One Earth Solar Farm

Applicants Response to Deadline 5 Submissions

Document Ref: EN010159/APP/9.42

December 2025

Figure 4.1: Barred Route Plan

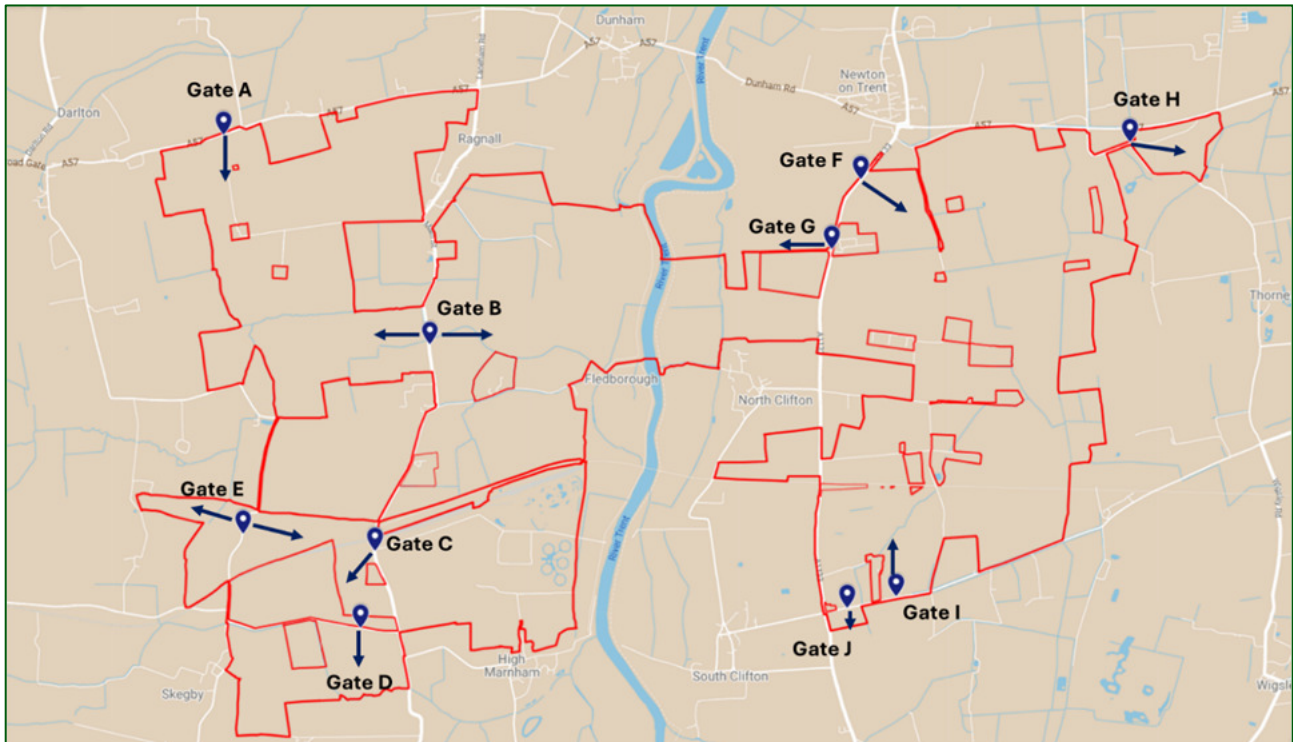
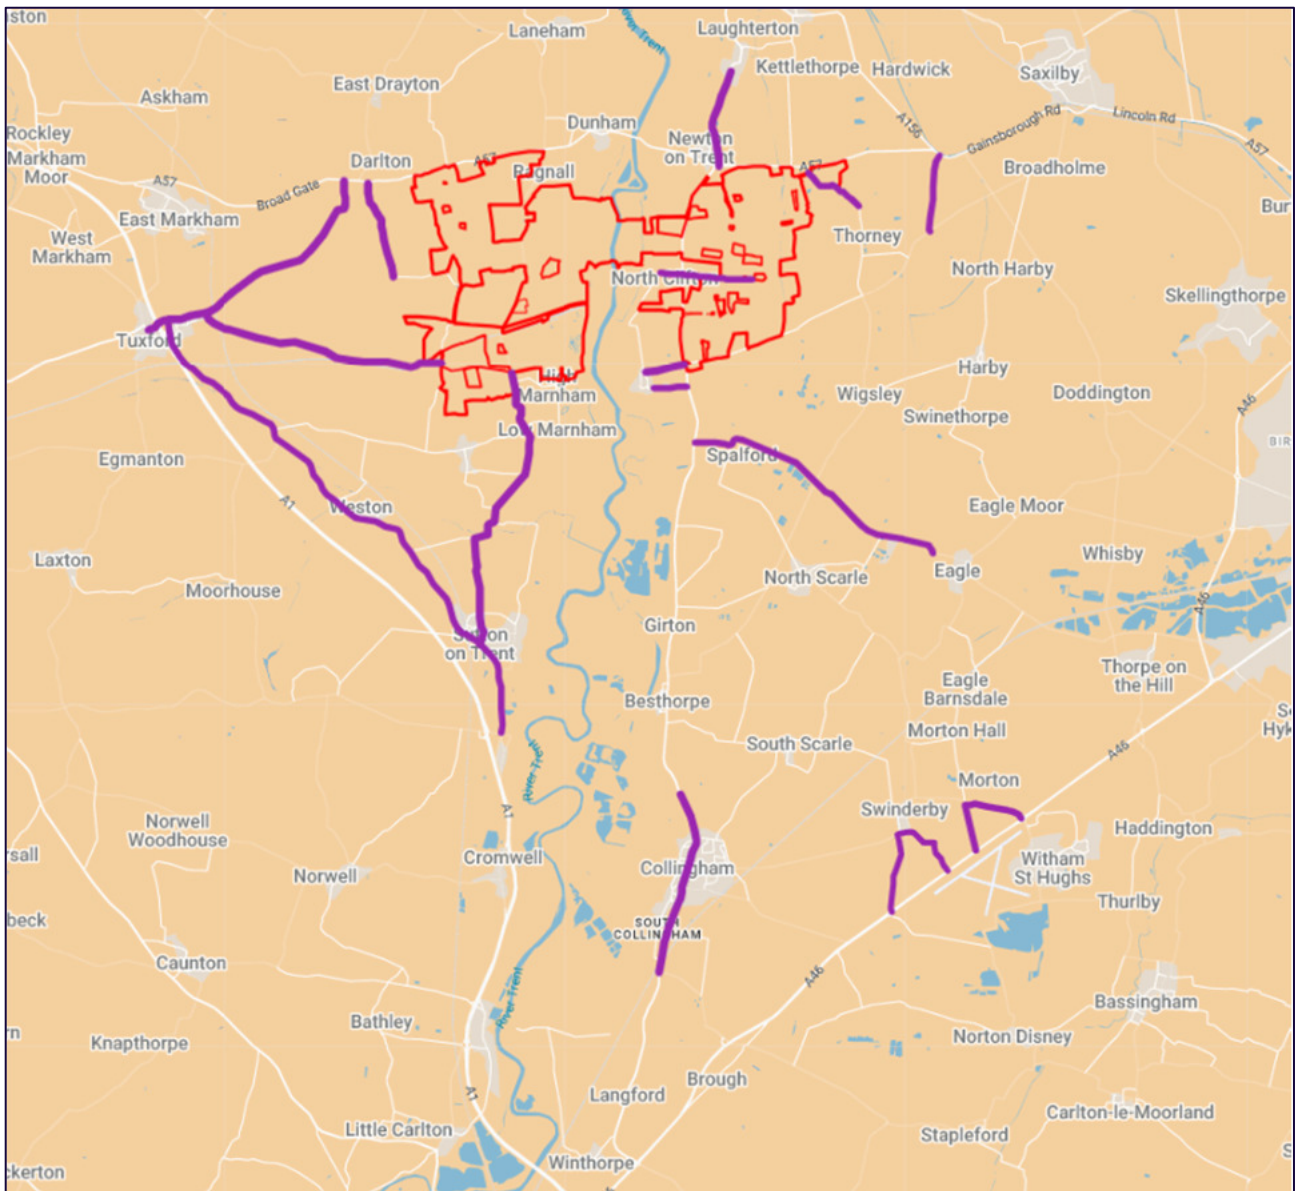
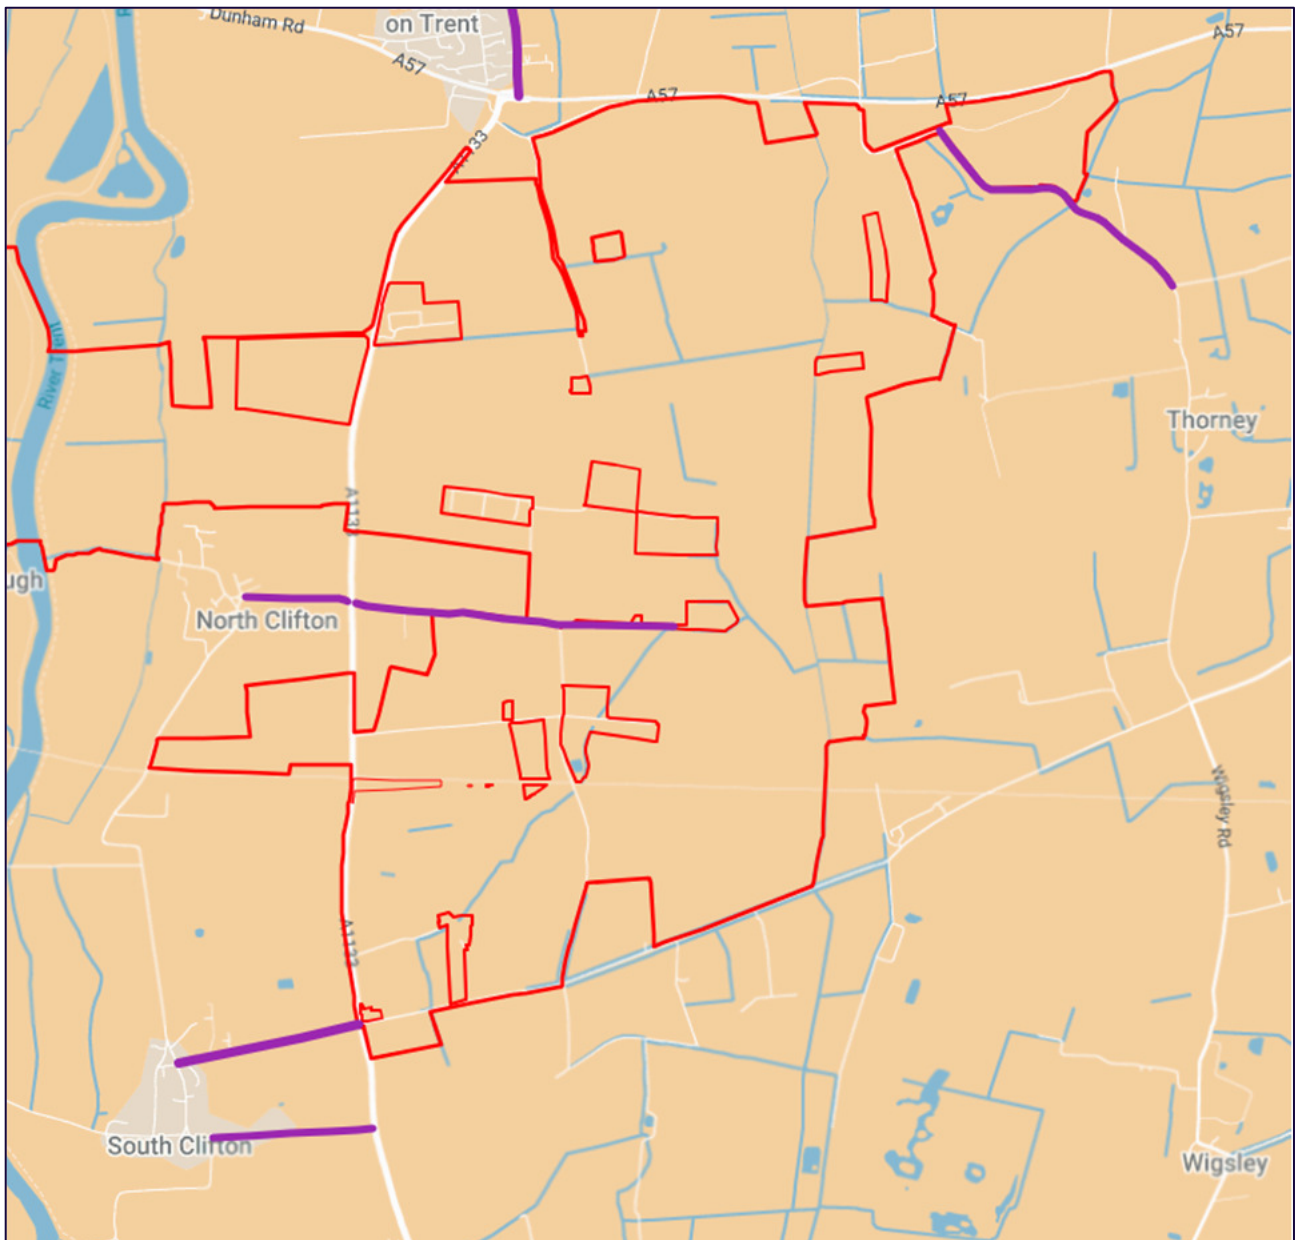
Transport			
D5R25	<p>Nottinghamshire County Council</p> <p>Responses to ExAQ2 Q18.0.1</p>	<p>NCC no longer believe this to be an acceptable position.</p> <p>Paragraph 1.2.3 of the Nottinghamshire Highway Design Guide (NHDG), states that new accesses or the increased use of existing accesses on classified or unclassified roads will normally be supported where there is not a road safety problem or where a road safety problem can be removed and it is considered that the appropriate way to determine</p>	<p>The Applicant confirms that Road Safety Audits will be undertaken for all proposed accesses as part of the technical approval process. These audits will be provided from follow the standard process from Stage 1 through to Stage 4 (as required), based on the refined junction designs prepared at the detailed design stage. The commitment to carry out a Road Safety Audit in advance of construction works is secured in paragraph 3.2.7 of the Outline CTMP [REP5-040].</p>

D5R26	Nottinghamshire County Council	(1) A ghost island would only be appropriate during construction and potentially decommissioning, if	Matters relating to the A57 junction have been addressed in the A57 Access Note (November 2025). One final drawing update is being prepared to clarify the stopping sight distance and revised

App Ref	Document Ref	Summary	Applicant Response
		<p>the safety of an access is through the Road Safety Audit process. Whilst the NHDG does not discriminate between classified and unclassified roads, NCC initially only requested this information for accesses onto classified roads, as a reasonable approach.</p> <p>On subsequently checking the classified road network, this includes the A57 (RSA supplied) and it is noted that an RSA is also submitted for Roadwood Lane which is a C classified road. Other accesses are on the A1133 (but accesses are not proposed within Notts here), Main Street/Ragnall Road (C2), Moor Lane (C81), Polly Taylors Road (C77). The only accesses that would not come under this strategy would be Gate E. However, in considering the information for the LIR it was noted that the visibility splays for these junctions cross where solar panels are proposed, which would obstruct visibility and represent a highway safety issue.</p> <p>NCC therefore believe that Road Safety Audits should be carried out at all accesses so that such issues can be identified at the appropriate time as this has implications for either the accesses proposed or the extent of solar arrays.</p>

App Ref	Document Ref	Summary	Applicant Response
	Responses to ExQ2	<p>decommissioning is the reverse of construction. It would not be necessary in the operational phase.</p> <p>(2) There are risks to road safety during the operational phase as, without vehicles using a ghost island on a regular basis, there is a risk that drivers would see as suitable for overtaking. A temporary amendment to accommodate a suitable layout would be acceptable, if required.</p> <p>(3) The applicant has not provided any further assessment of the operation of the junction during construction nor demonstrated that forward visibility to the junction is available over a distance of 1.5 times the required stopping sight distance. This means that the length of any potential queuing is unknown, and it is unclear if the back of any queue could be seen in sufficient time.</p> <p>(4) A report has been supplied to NCC - A57 Access Strategy Review dated September 2025. However, the report indicates that the peak construction traffic flow is 328 vehicles per day, occurring for one month only. However, the information provided in Table 4 of the Transport Assessment identifies that there are 92 light vehicles and 289 HGVs using the link to serve this access, a total of 381 which is an increase of 53 vehicles against that now suggested. If these vehicles were added to the construction traffic profile in Figure 2 of the A57 Access Strategy</p>	<p>visibility splay, which the Applicant and Council agree can be delivered. Upon issue of the revised drawing, the Statement of Common Ground for this item will be fully agreed, closing the A57 access junction matter out in its entirety.</p>
